Our Ref: BTC00
Your Ref:
Date: 12th February 2021

**DEADLINE 3 – APPLICATION BY HIGHWAYS ENGLAND FOR A DCO FOR THE A1 IN
NORTHUMBERLAND – MORPETH – ELLINGHAM
COMMENTS ON RESPONSES SUBMITTED FOR DEADLINE 2**

Drawing Title: Figure 2.6 Temporary Construction Works: Part B

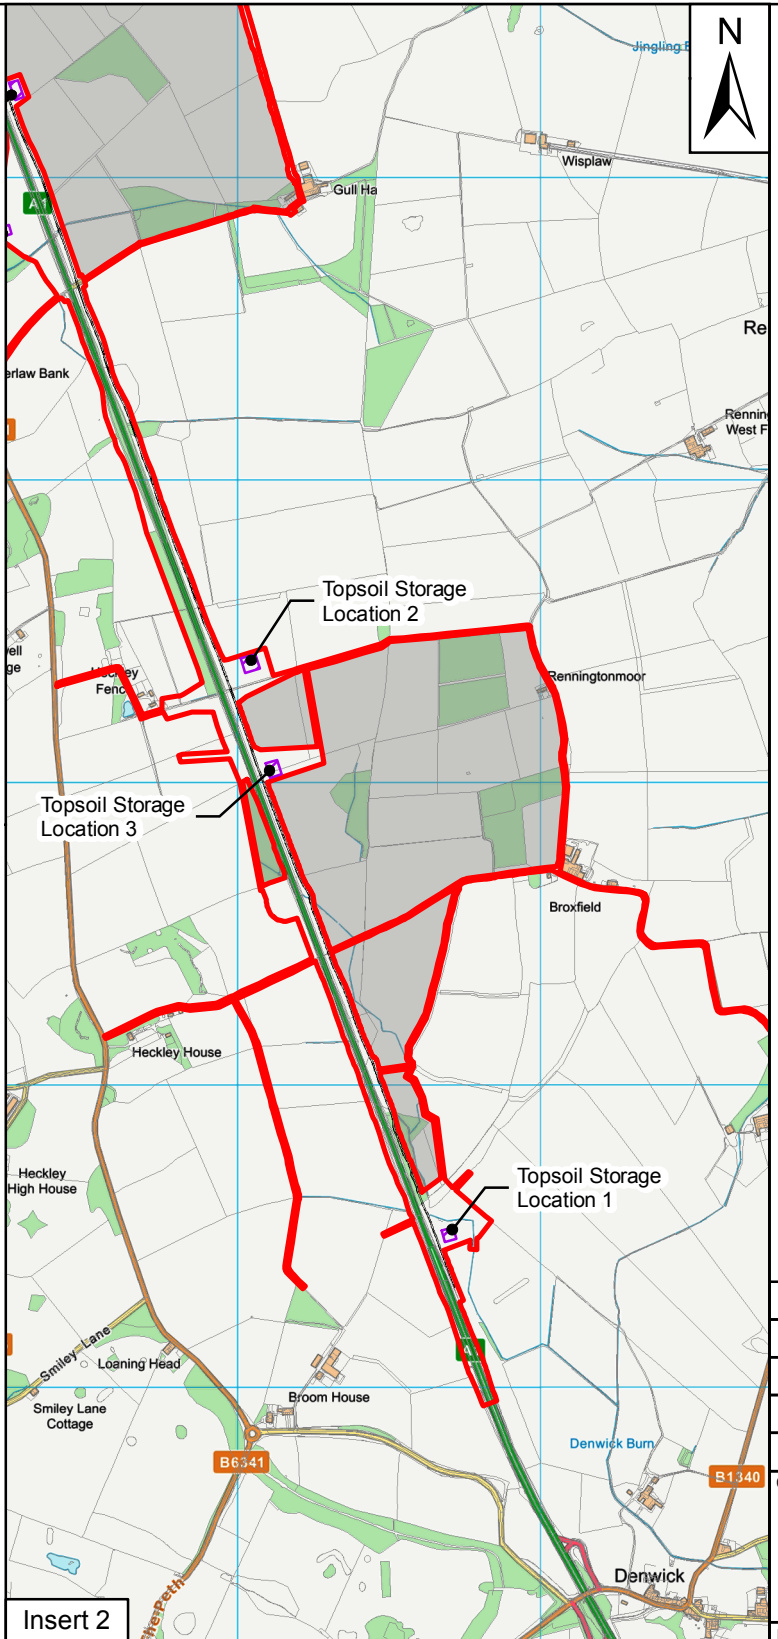
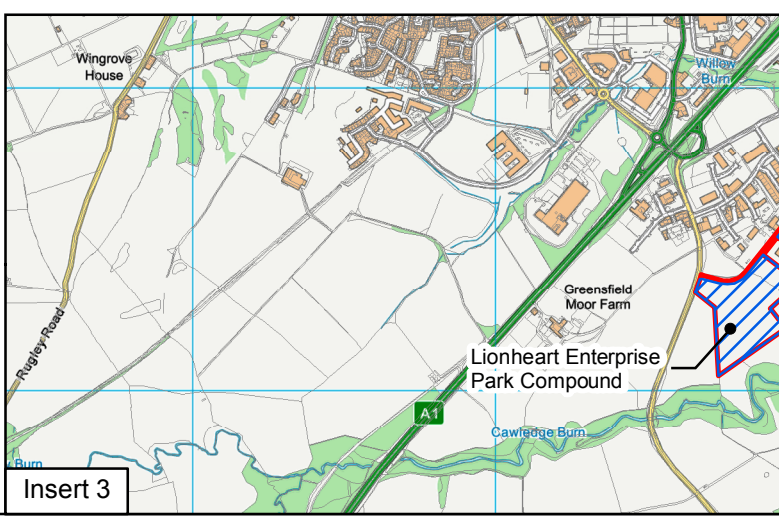
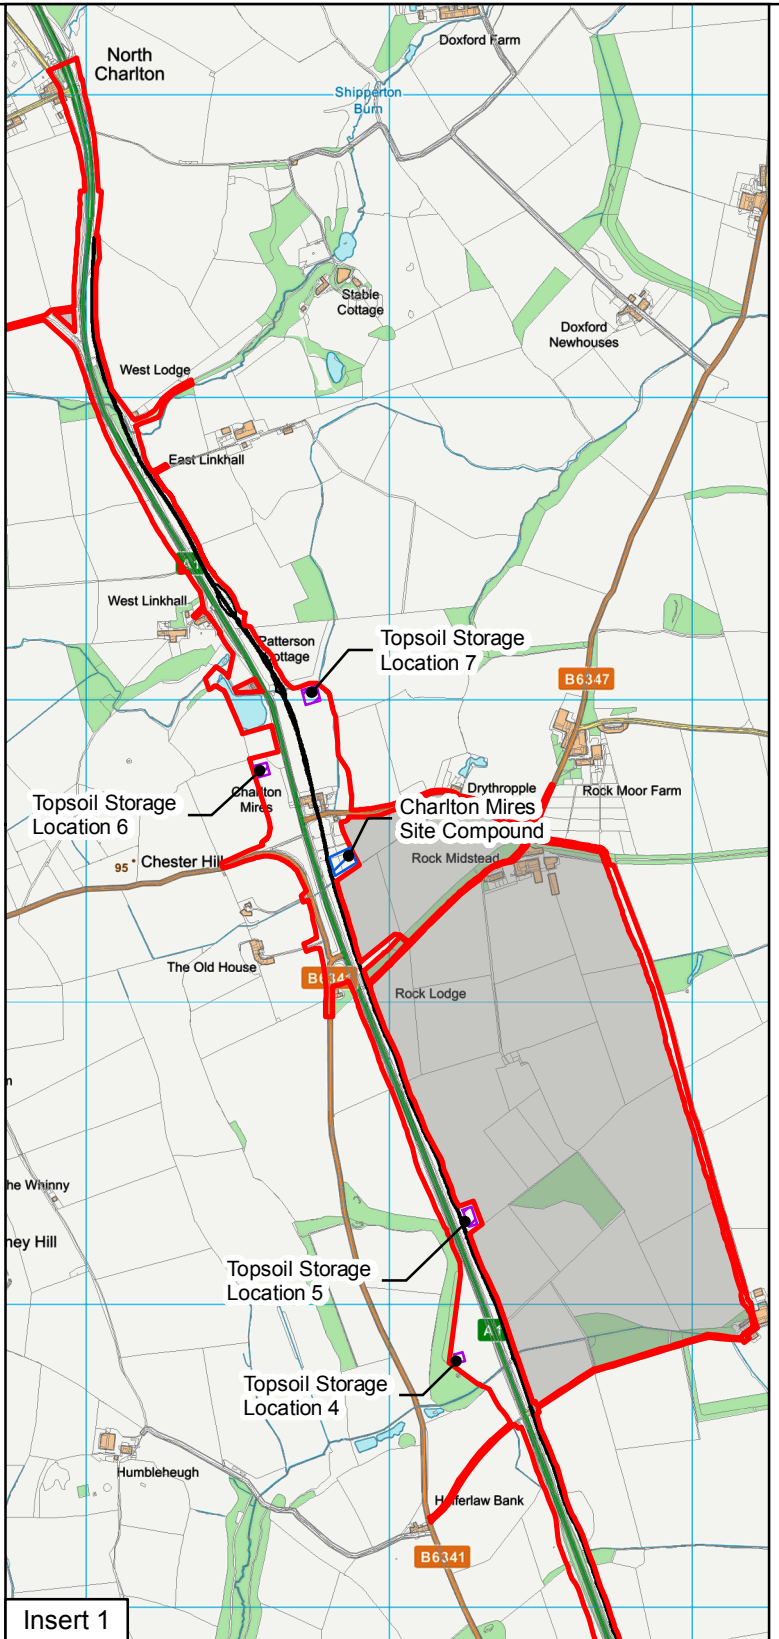
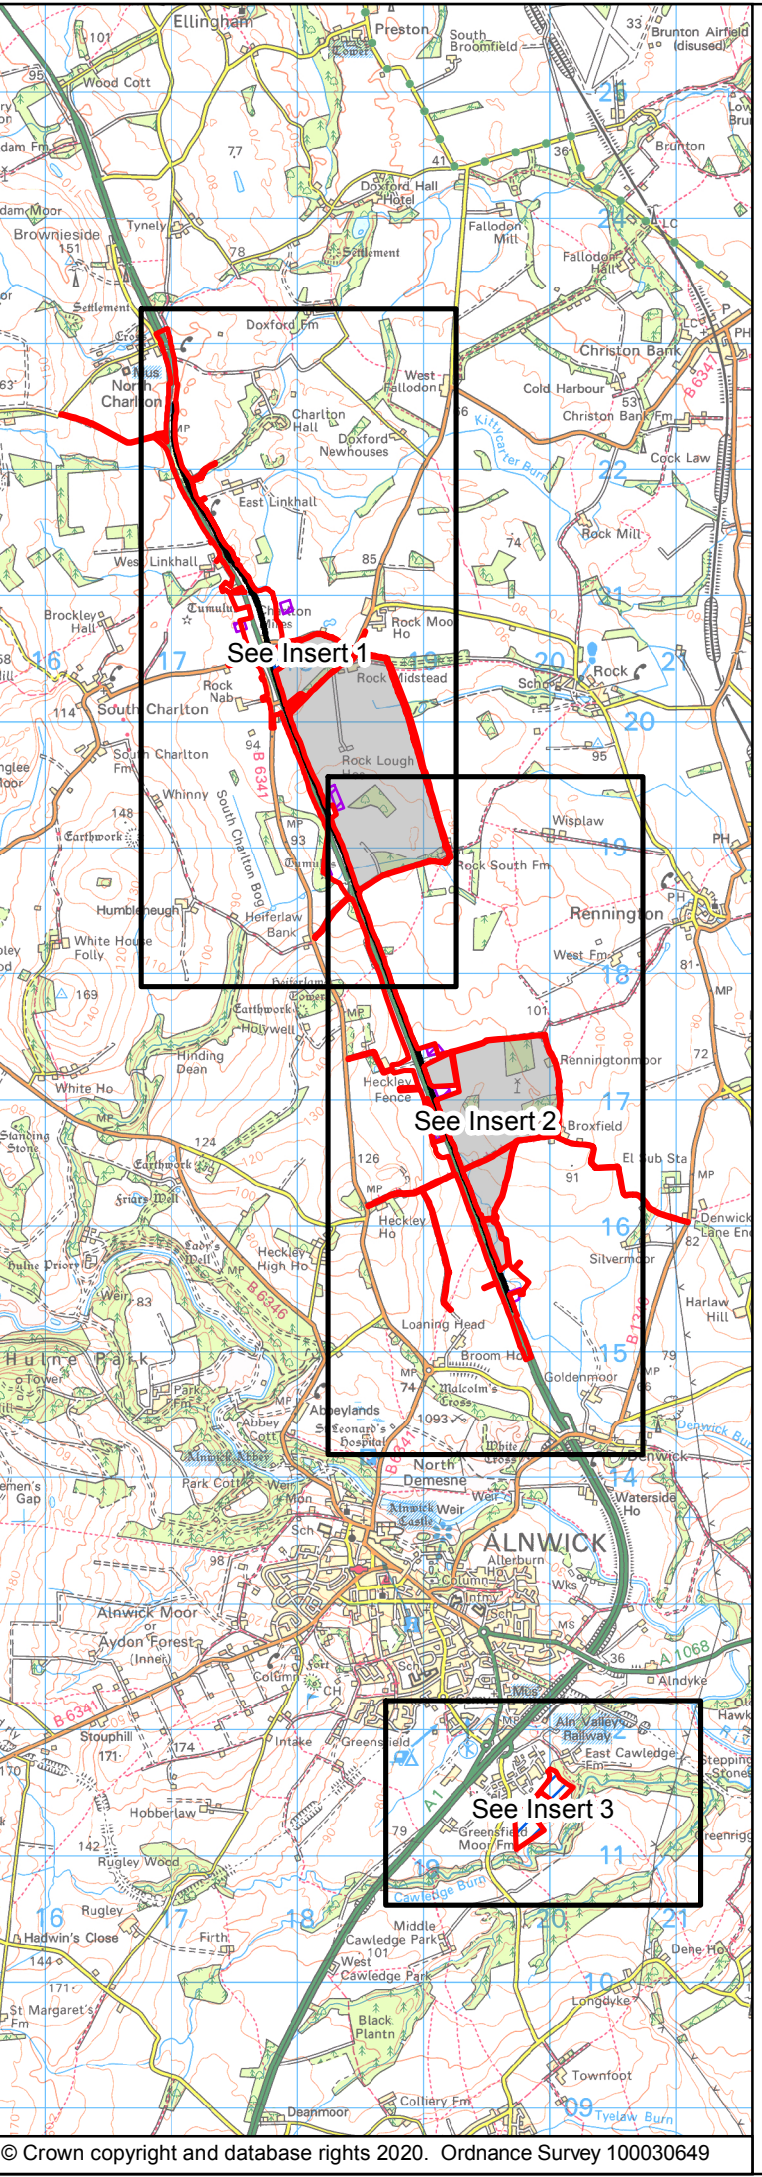
2. Topsoil Bunds – we note submission of Document TR010059 – 001100 6.1 ES Part B Fig 2.6 Temporary Construction Works. The document notes the proposed location of temporary topsoil bunds. We do not agree that Topsoil Location 5 is necessary. HE are proposing to acquire a large parcel of land to the west of Location 5, where Location 4 is noted. It would seem sensible to use part of this land for Topsoil Location 5 to avoid taking additional temporary land when it is not necessary. Location 5 has not been well thought out given it is located on a field boundary and blocking up access between fields and is also in a very low-lying area of land that floods during wet weather and winter months. This would not be a suitable location and it does not seem necessary to take additional temporary rights when there is a large area of unused land on the west side of the carriageway at Location 4 that would be more suitable.
